Charlotte Department of Transportation

Memorandum

Subject: Rezoning Petition 08-067: Located on the east side of Colwick Road
between Chiswick Road and Greenwich Road
(Revised 5/23/08)

TITLE:
CONCEPTUAL SITE PLAN

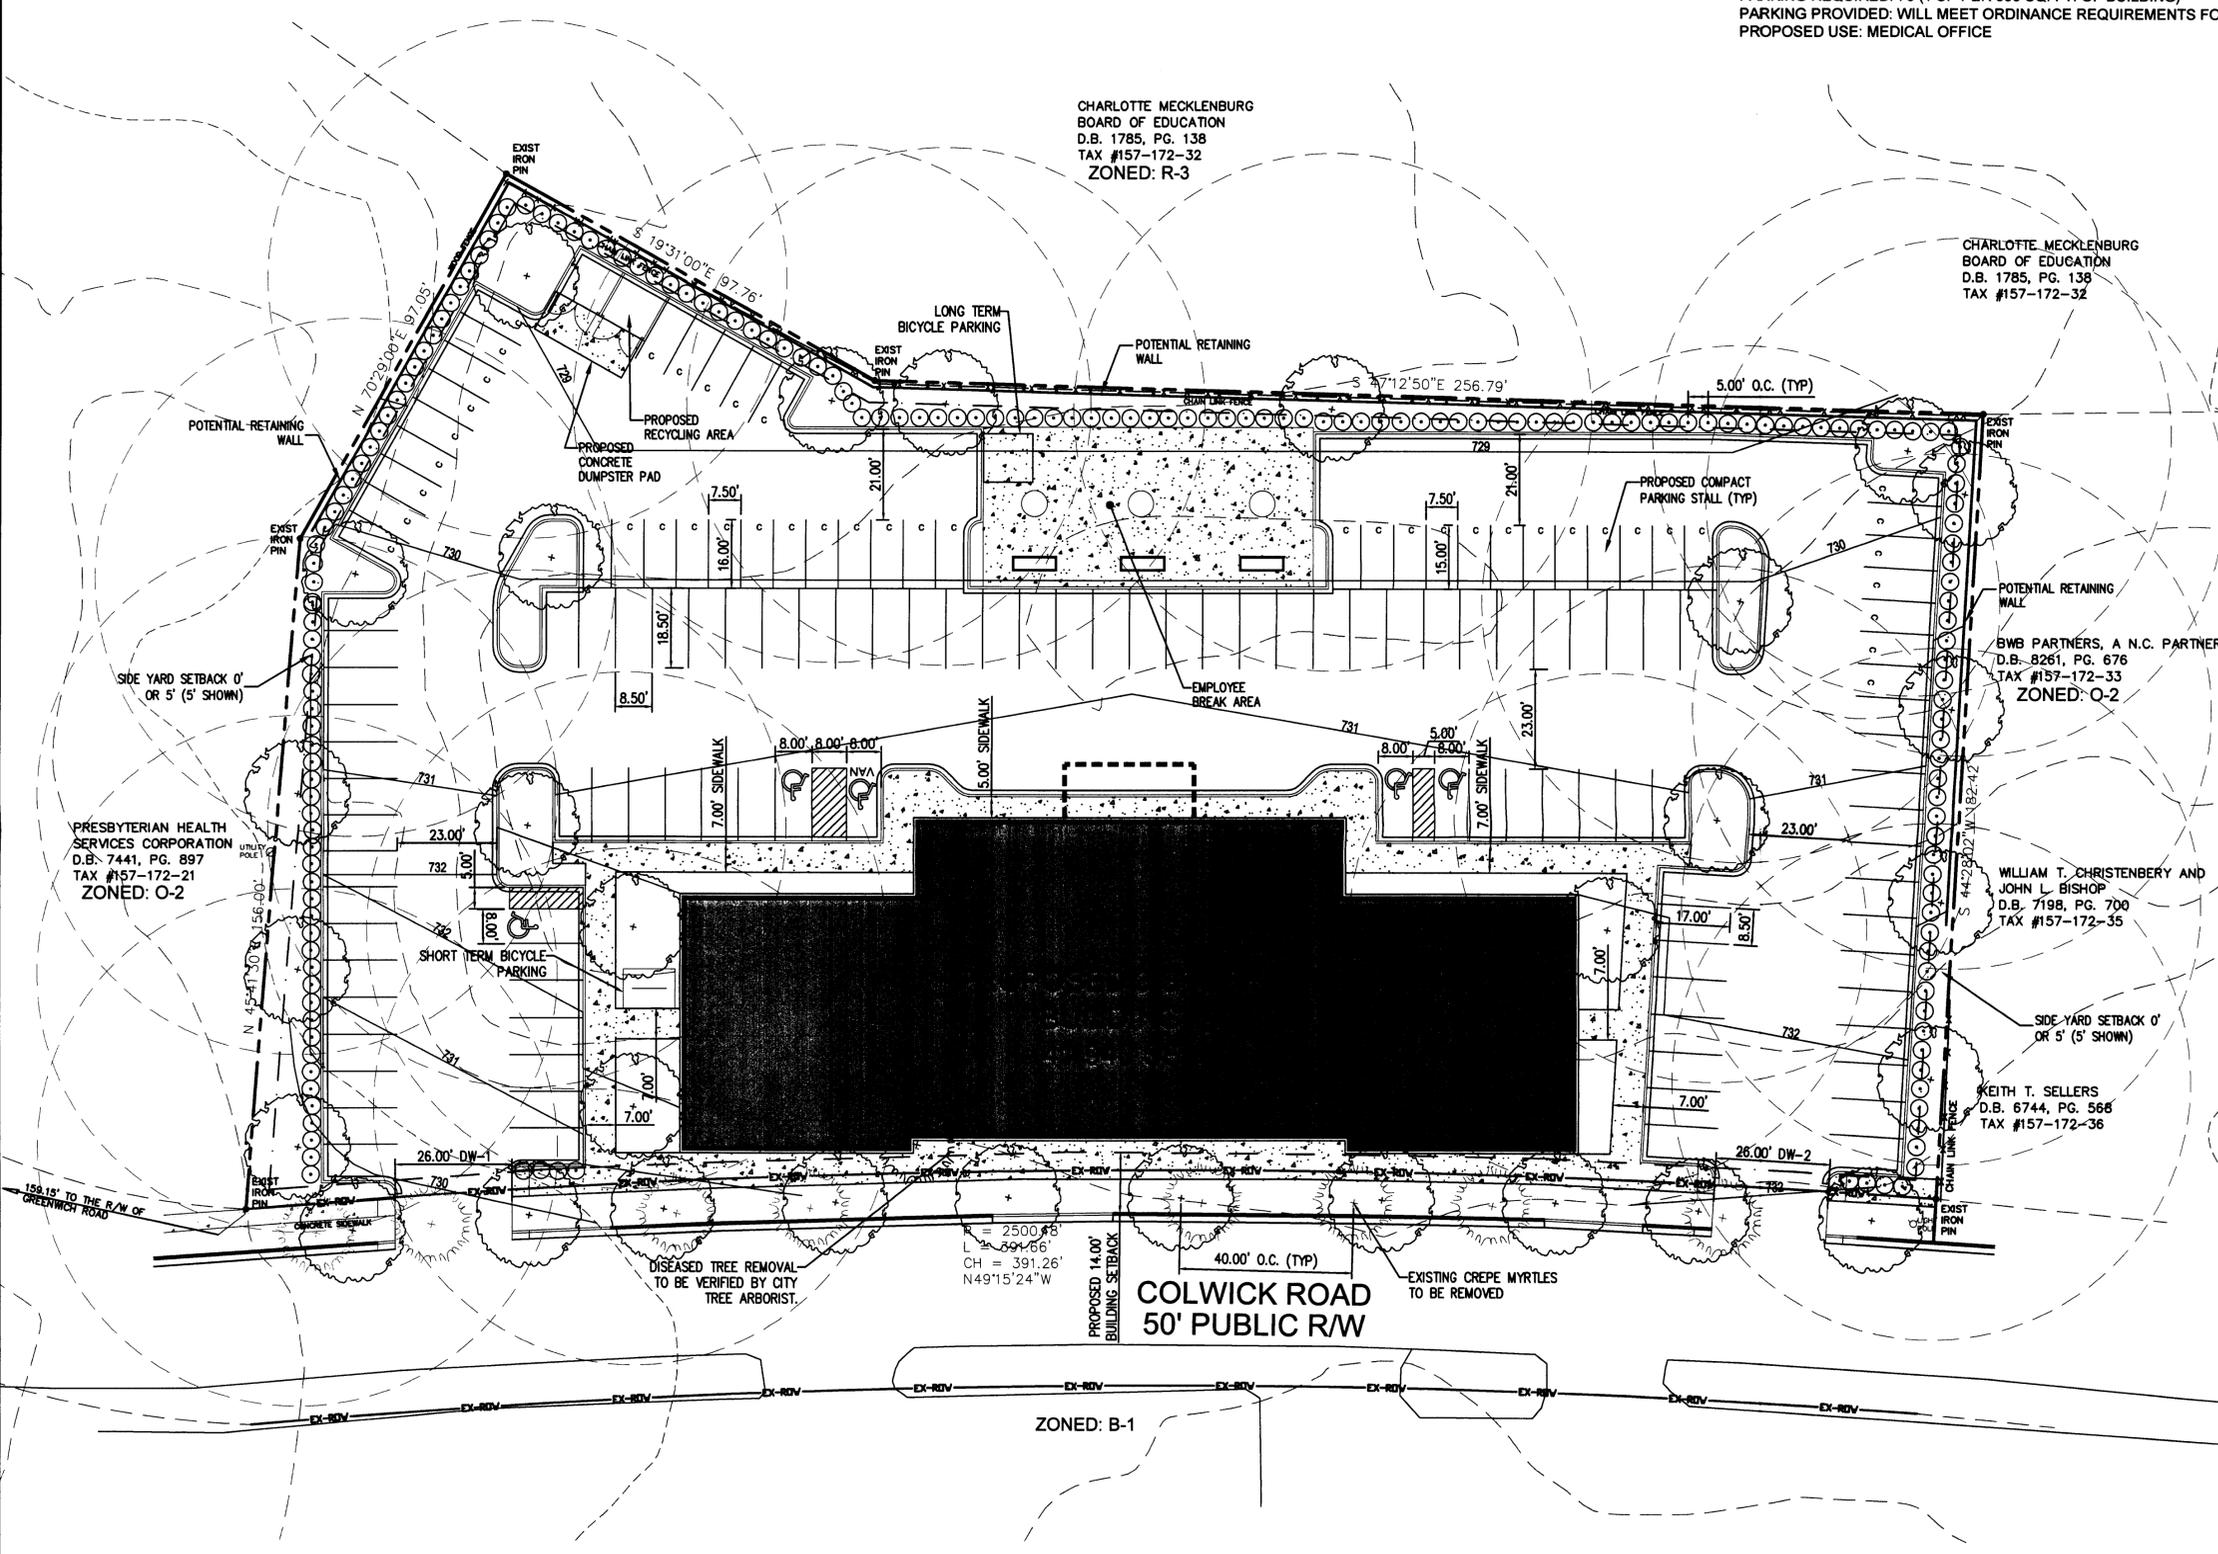
1. A pedestrian/bike path connection is needed to provide better access to Cotswold Elementary School for students accessing the school from North Sharon Amity Road. This pedestrian/bicycle connection would help to separate students/bicyclists from the only vehicular entrance to the school via Greenwich Road. This connection was specifically recognized as important in a Safe Routes To School walking audit of Cotswold School in late

2007. We believe that this connection should be provided, however, we are aware that the Cotswold Elementary School principal and CMS do not support this connection.
